Final Drainage Report

# Winsome Subdivision Filing No. 3 El Paso County, Colorado

PCD File No. SF-22-009

Prepared: February 2, 2023

WINSOME FILING NO. 3

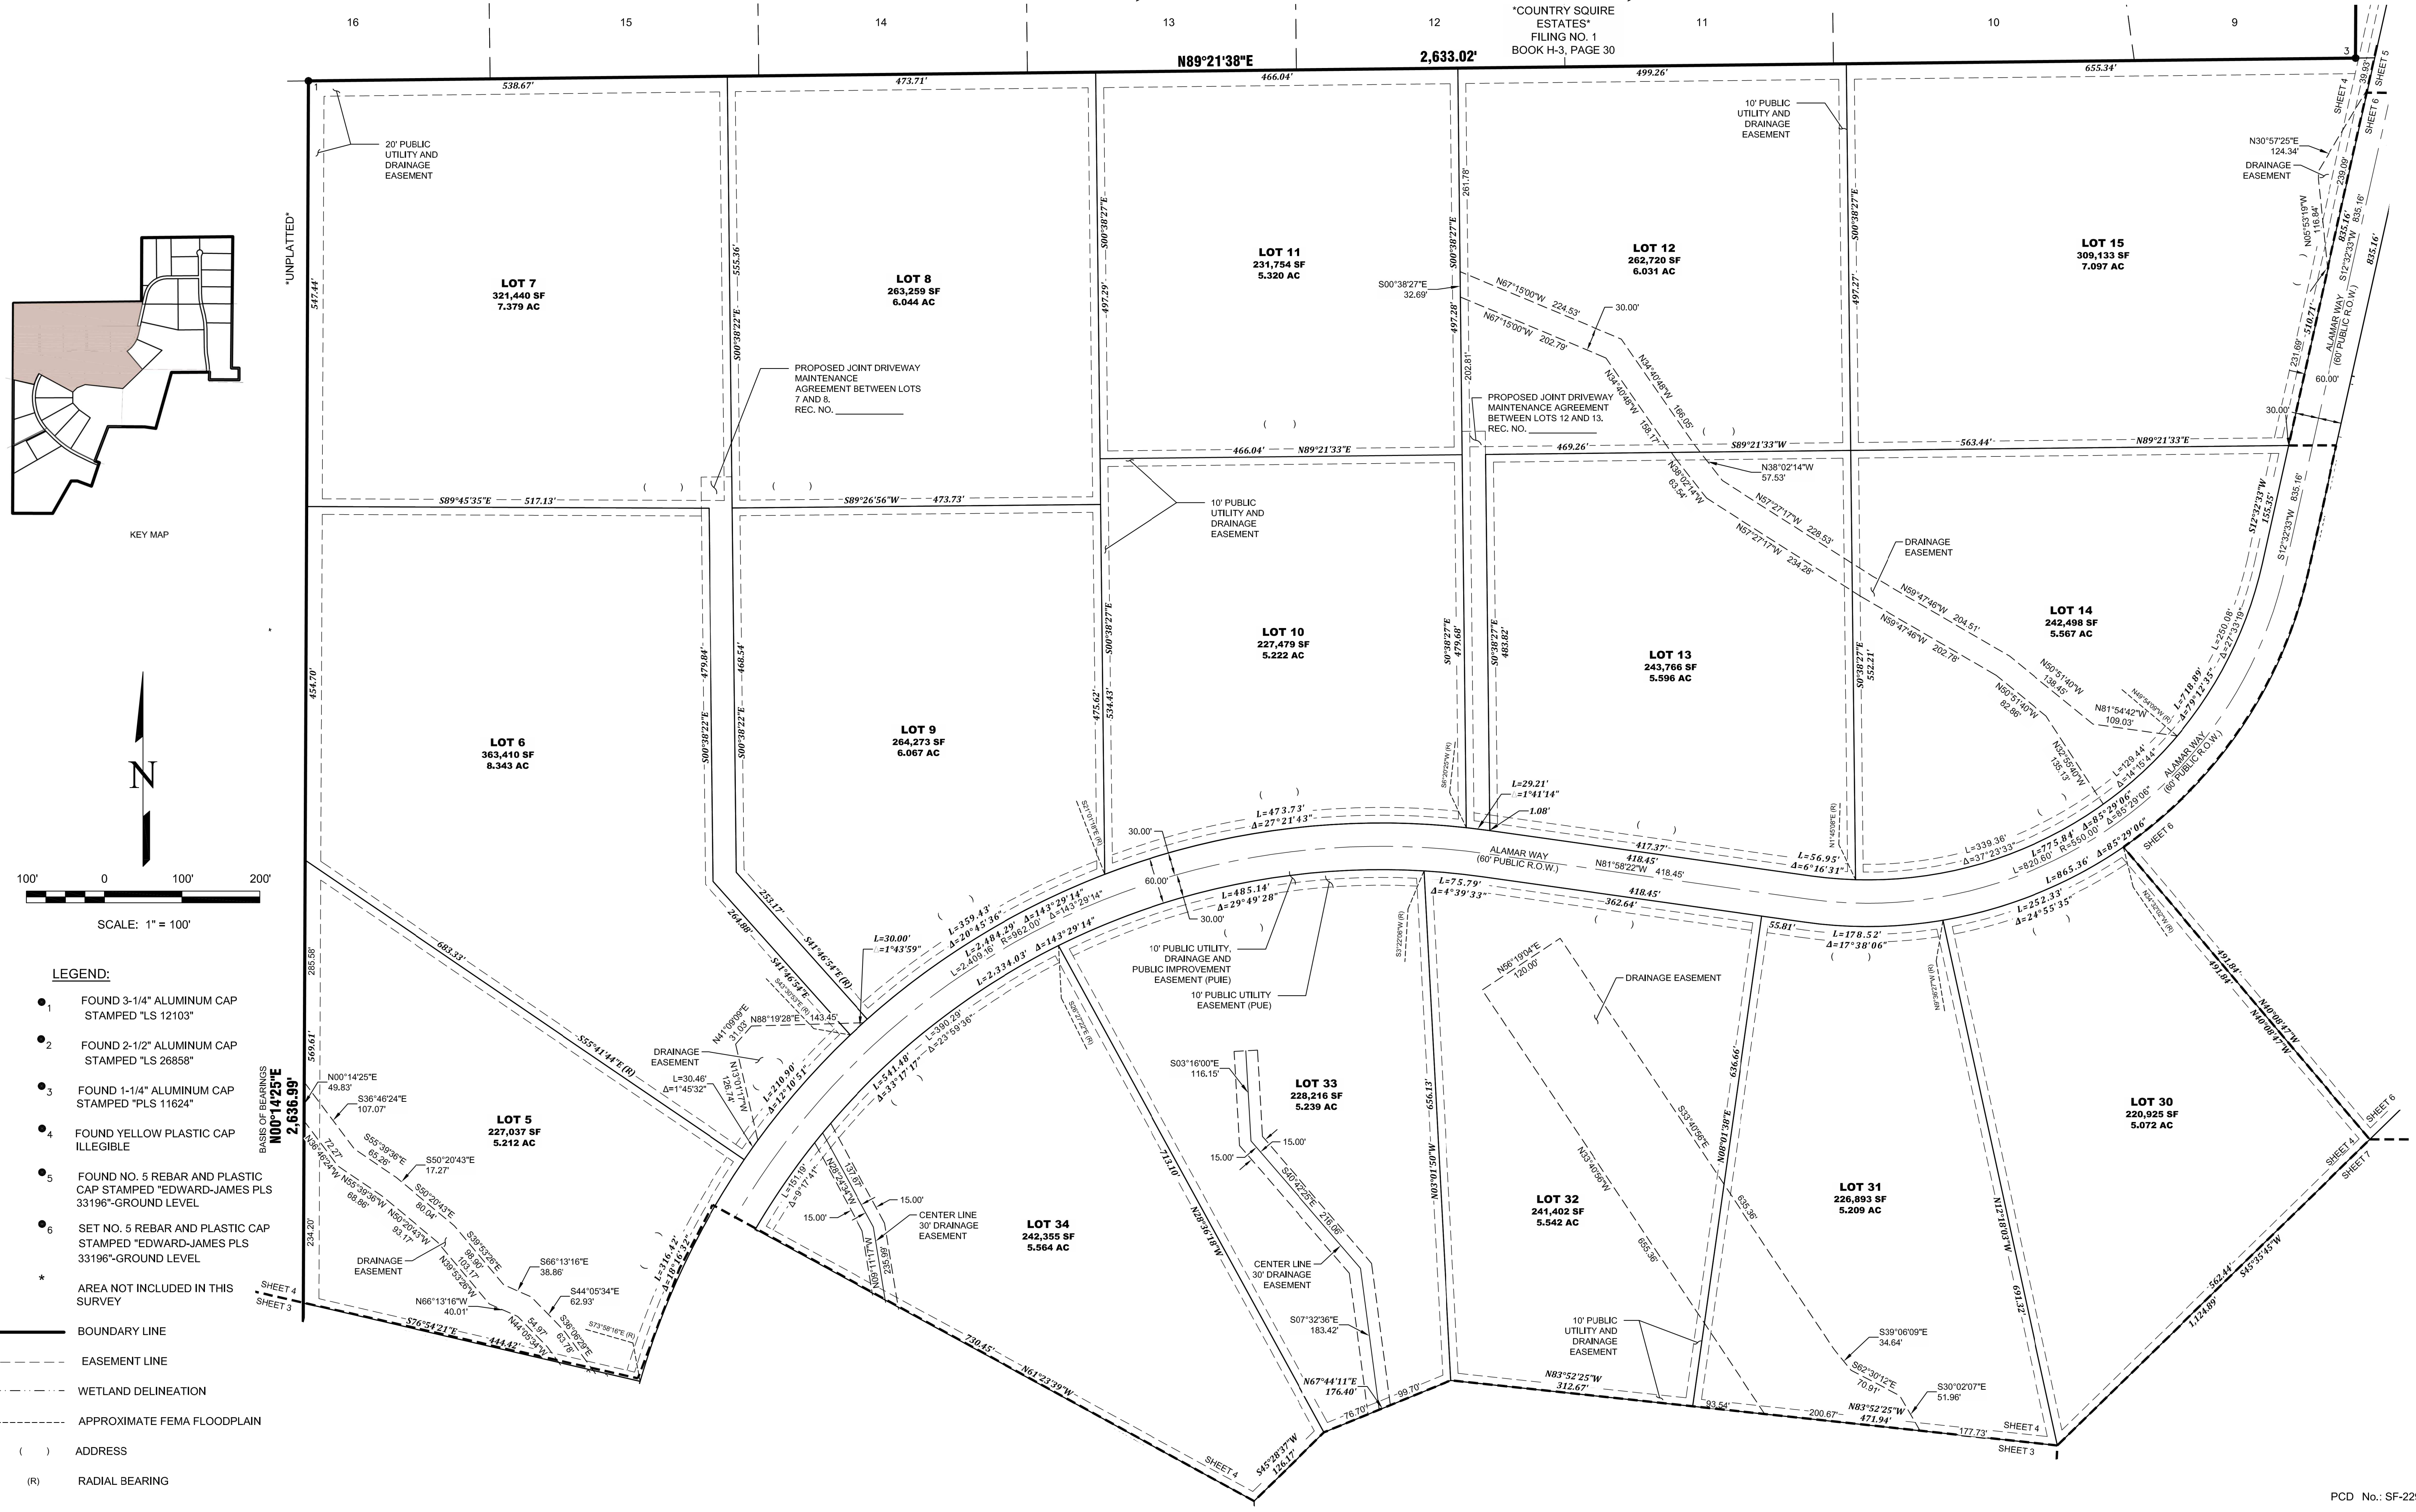
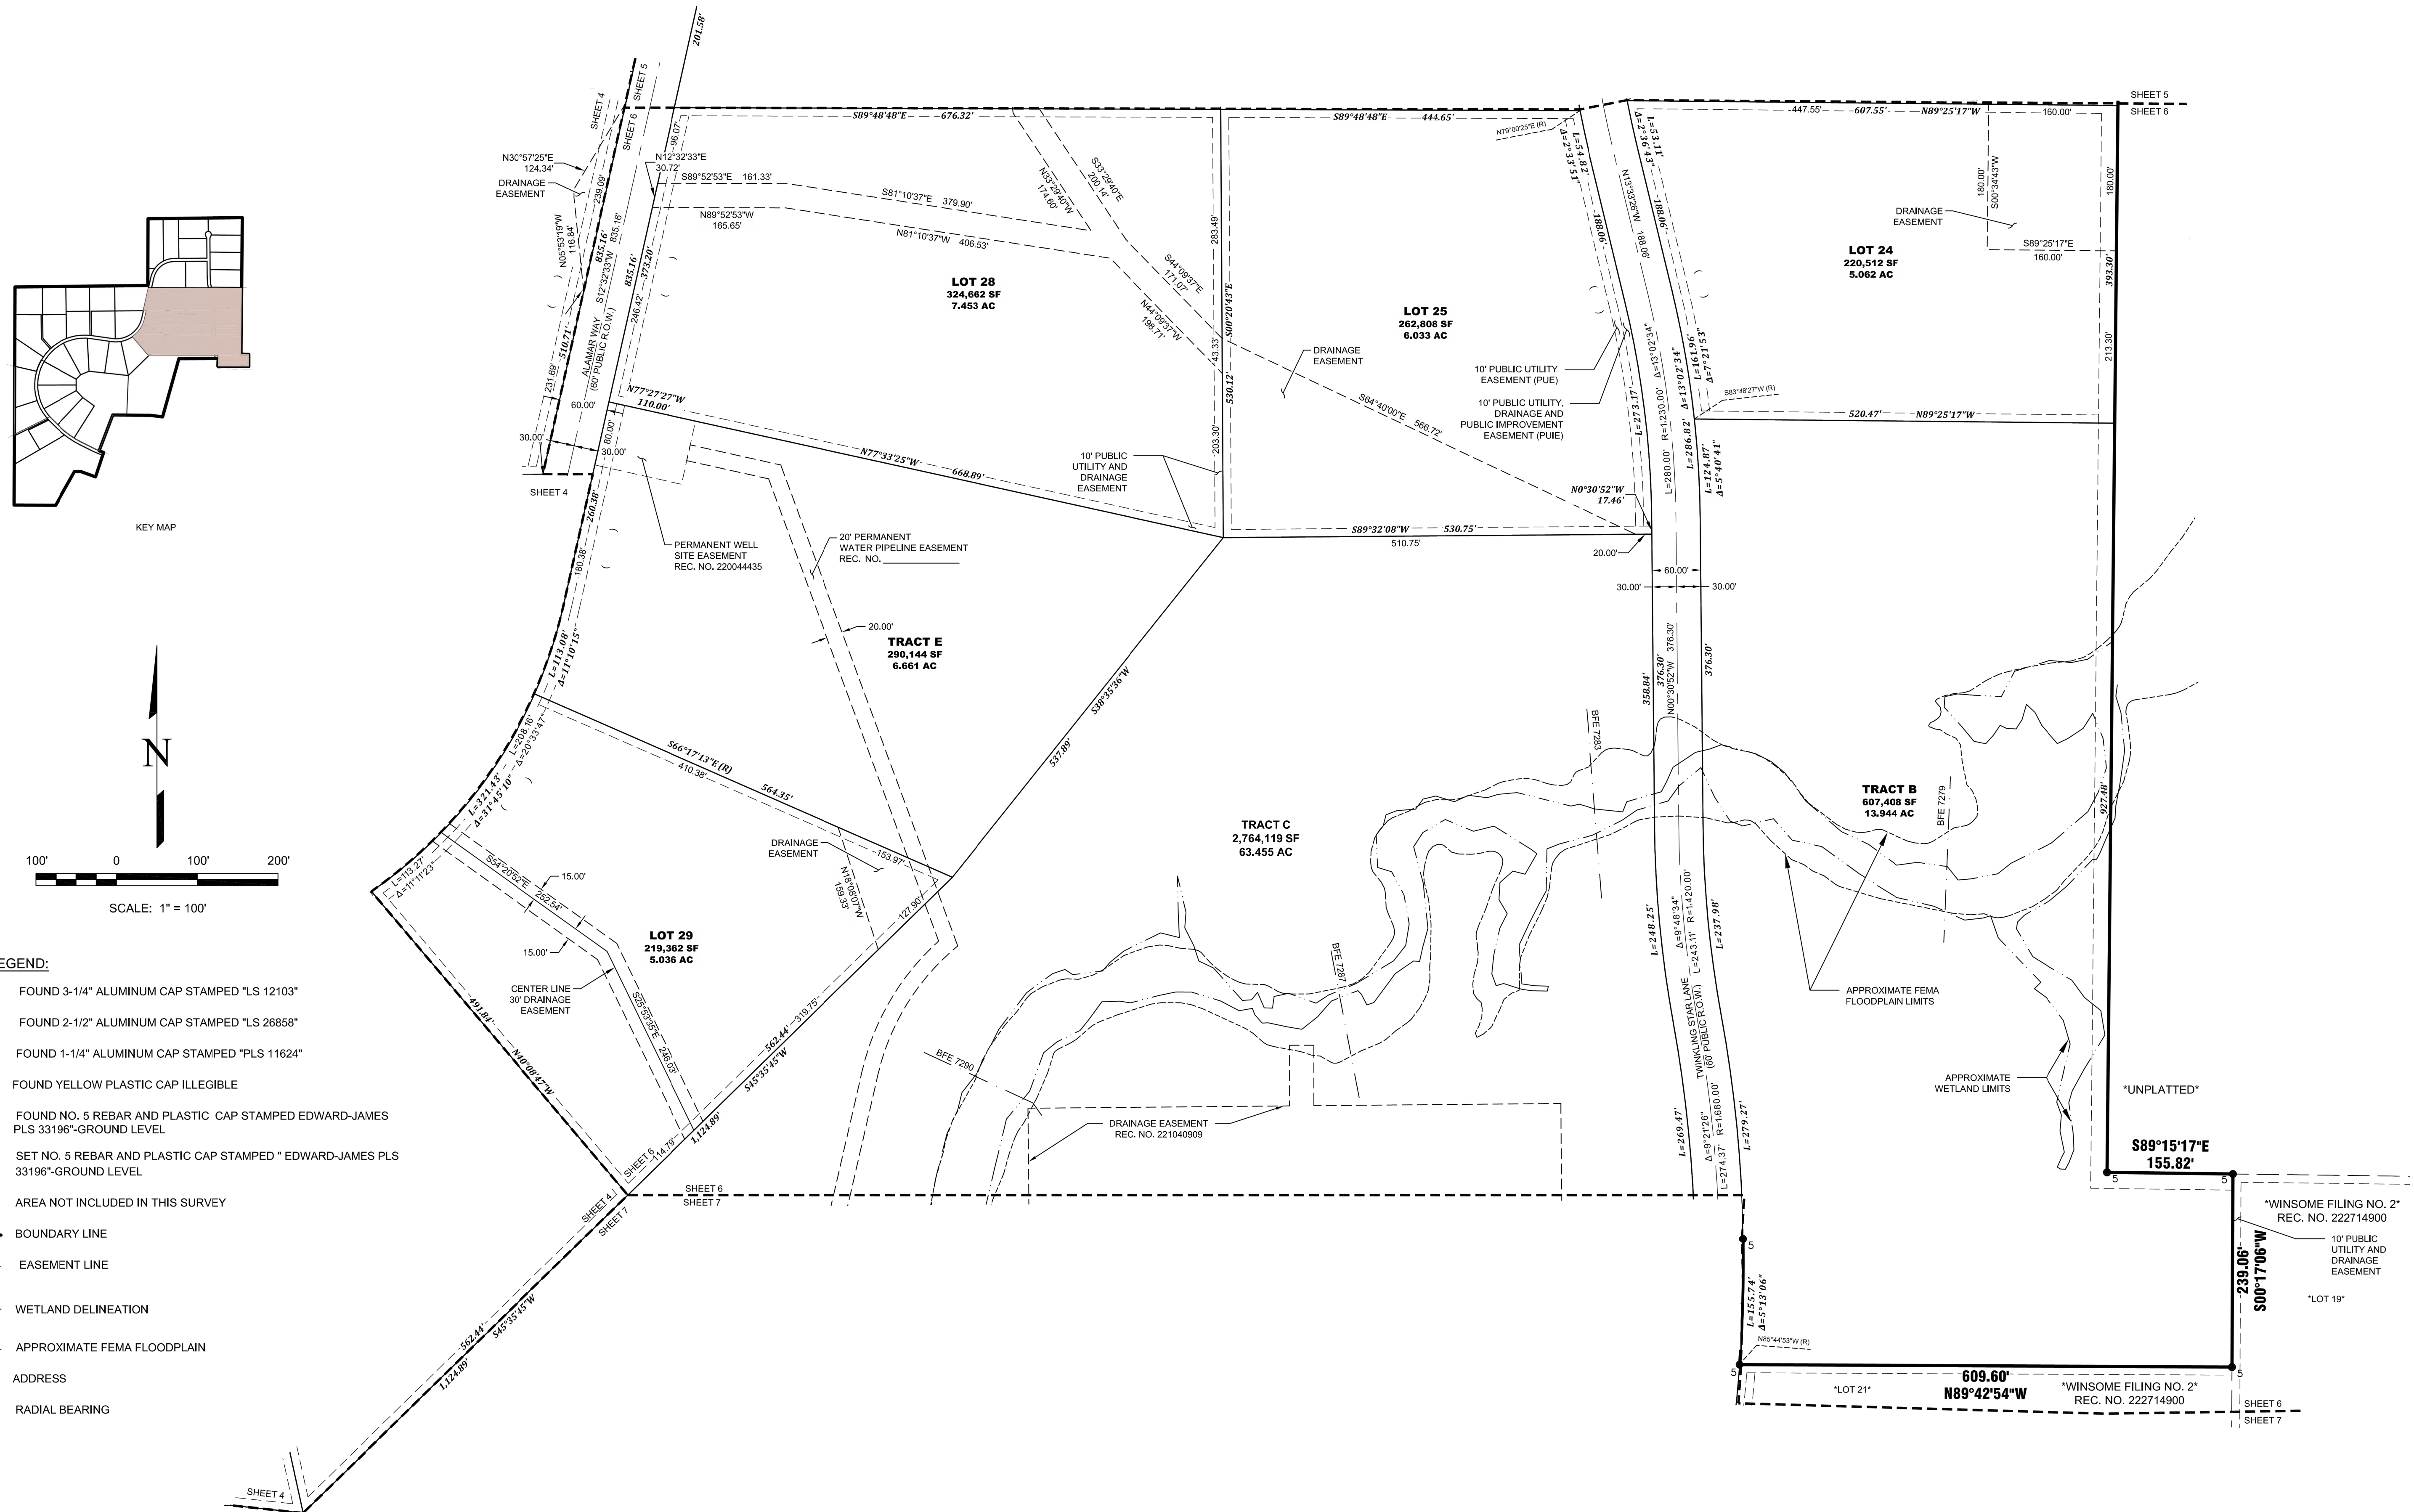
BFE's and floodplain extents from the CWCB risk map program accepted by FEMA to be shown on plat. contact Keith Curtis for approved BFE and floodplain extents shapefiles,  
"Roadway improvement across the creek" per note 7, require either a less than 6" rise certification per FEMA guidance, or an approved CLOMR from FEMA prior to requesting a local floodplain permit for this work .
